Our reference: ECM: 9476817  
Contact: Gavin Cherry  
Telephone: (02) 4732 8125

19 March 2021

**Response to Request for Advice on Oakdale West Estate Stage 3 Development  
SSD 9794683**

L.SK.200

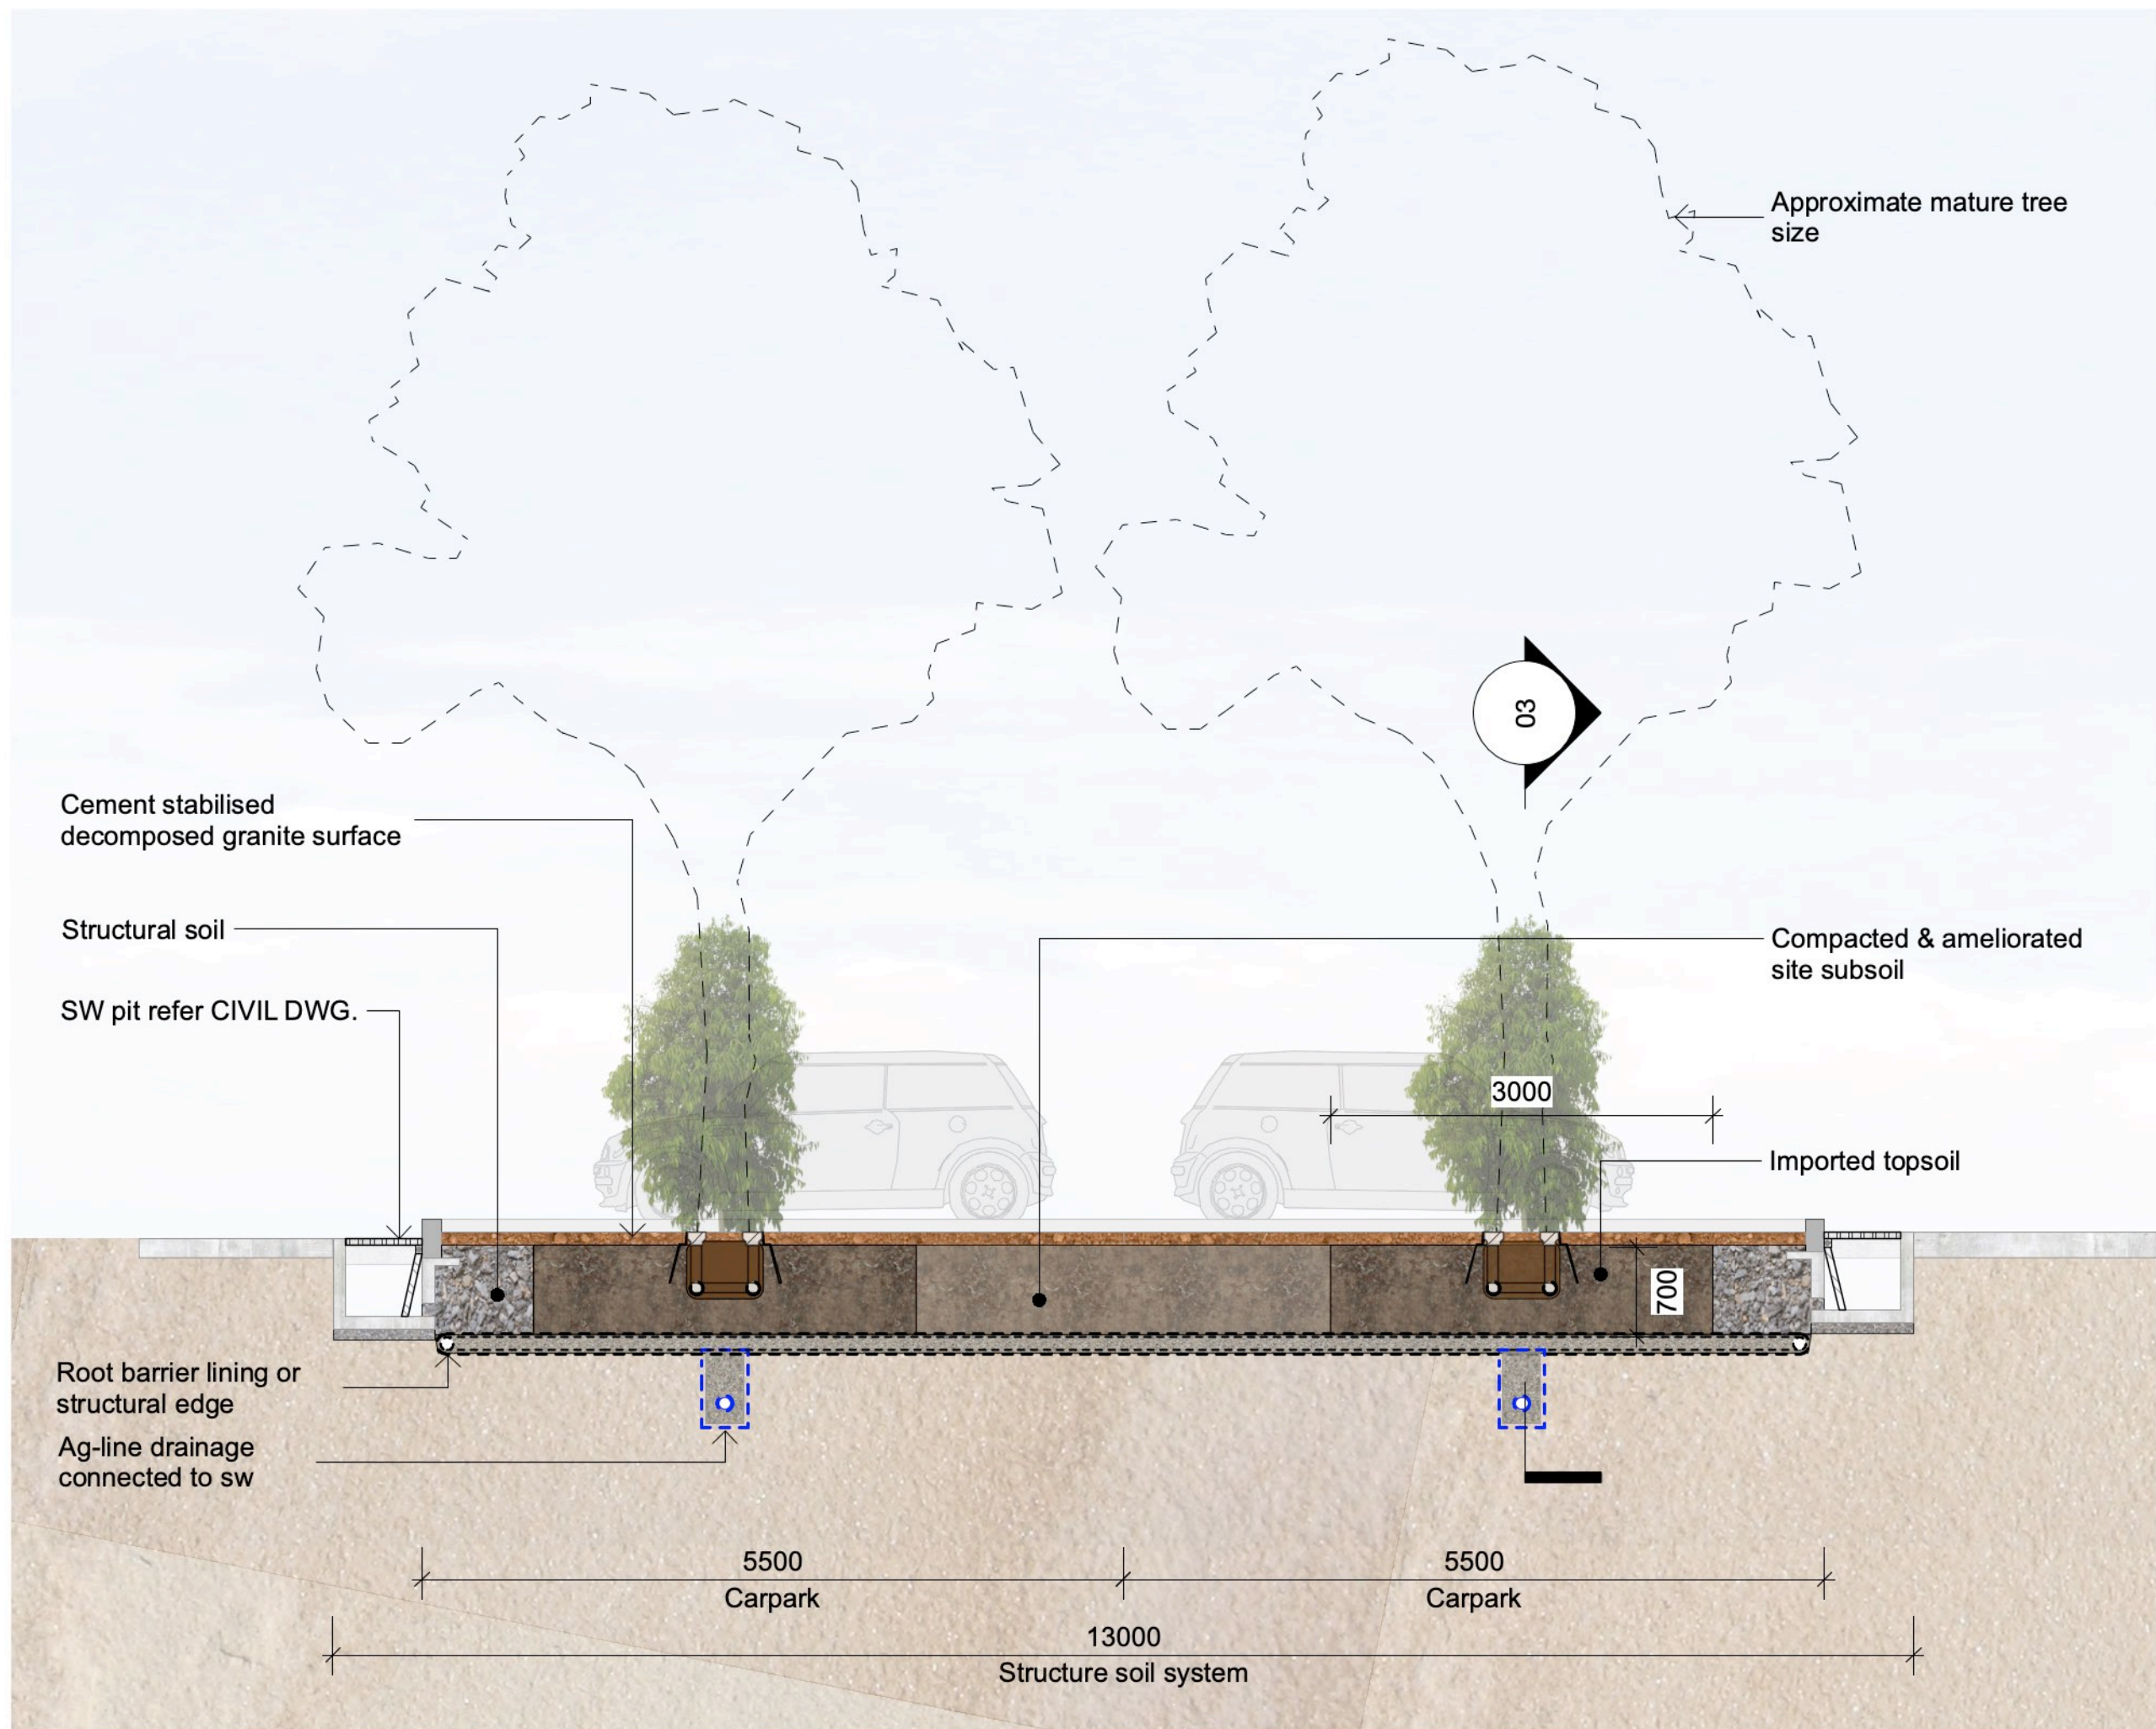
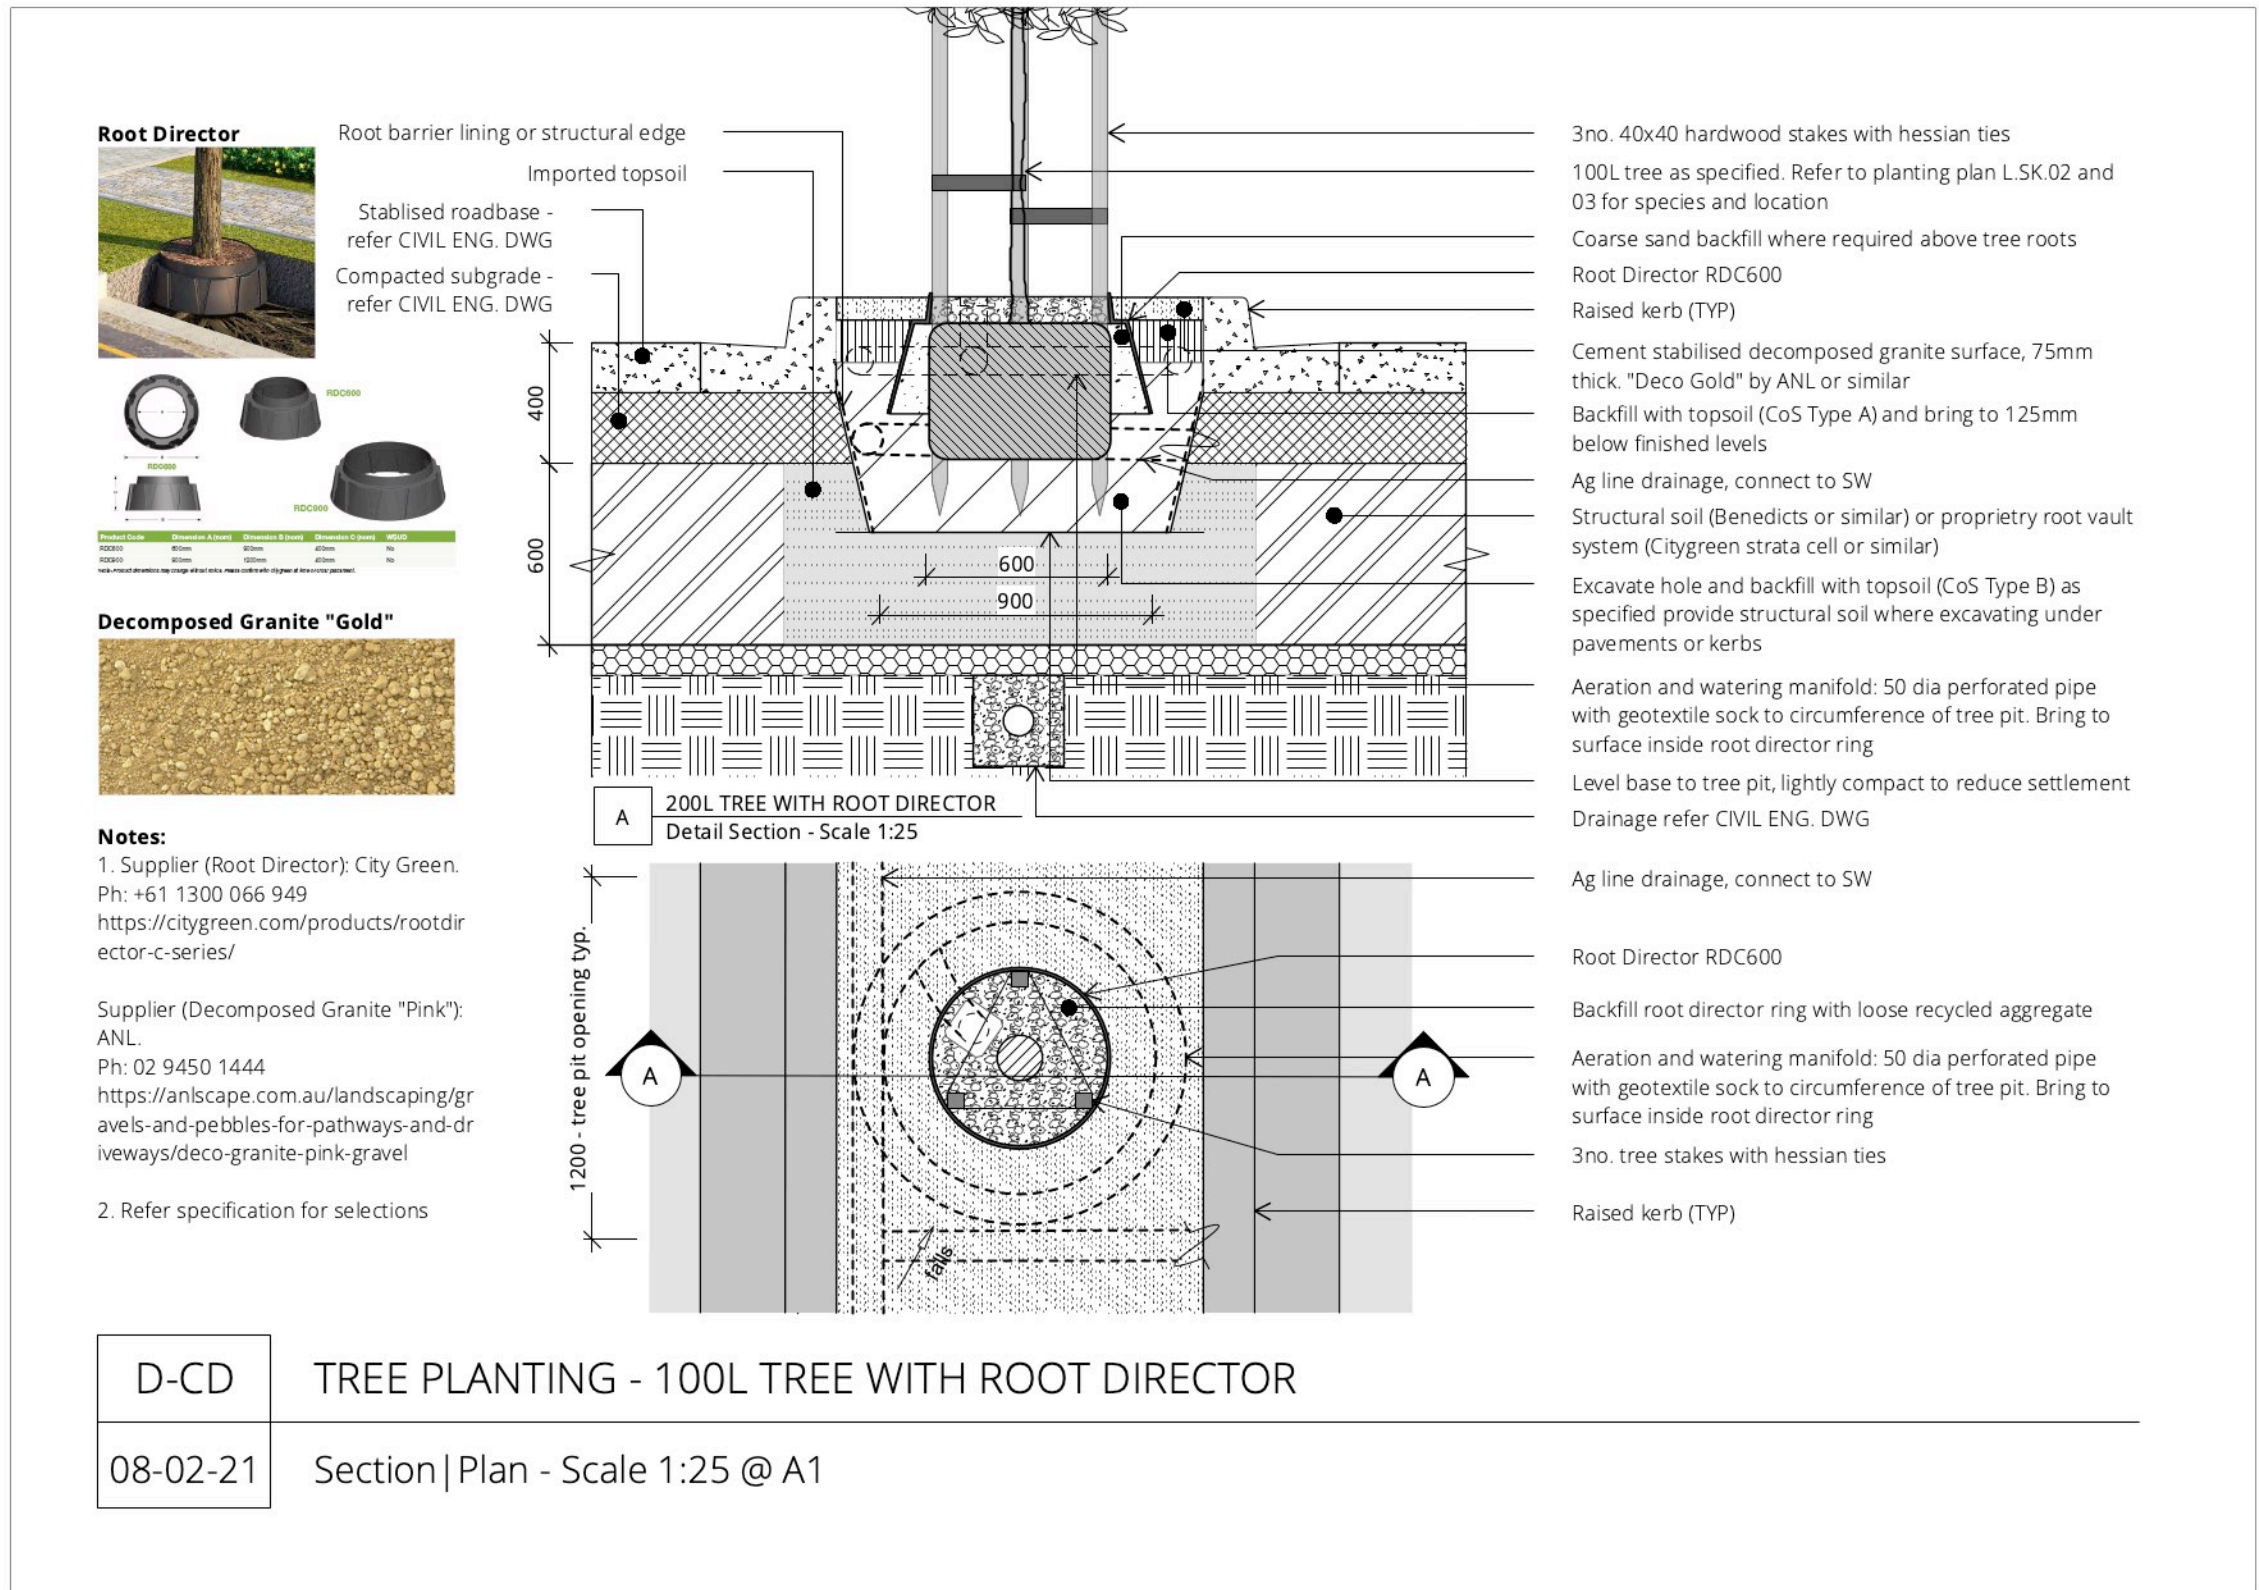
- Tree plantings in the pavement at Lot 2D and carpark areas are supported provided a suitably qualified and experienced arborist specifies the engineered tree pit details including structural soil volumes and materials, based on proposed species. This is to ensure the best possible growing conditions for long term tree health and viability (refer sheet LSK.200)
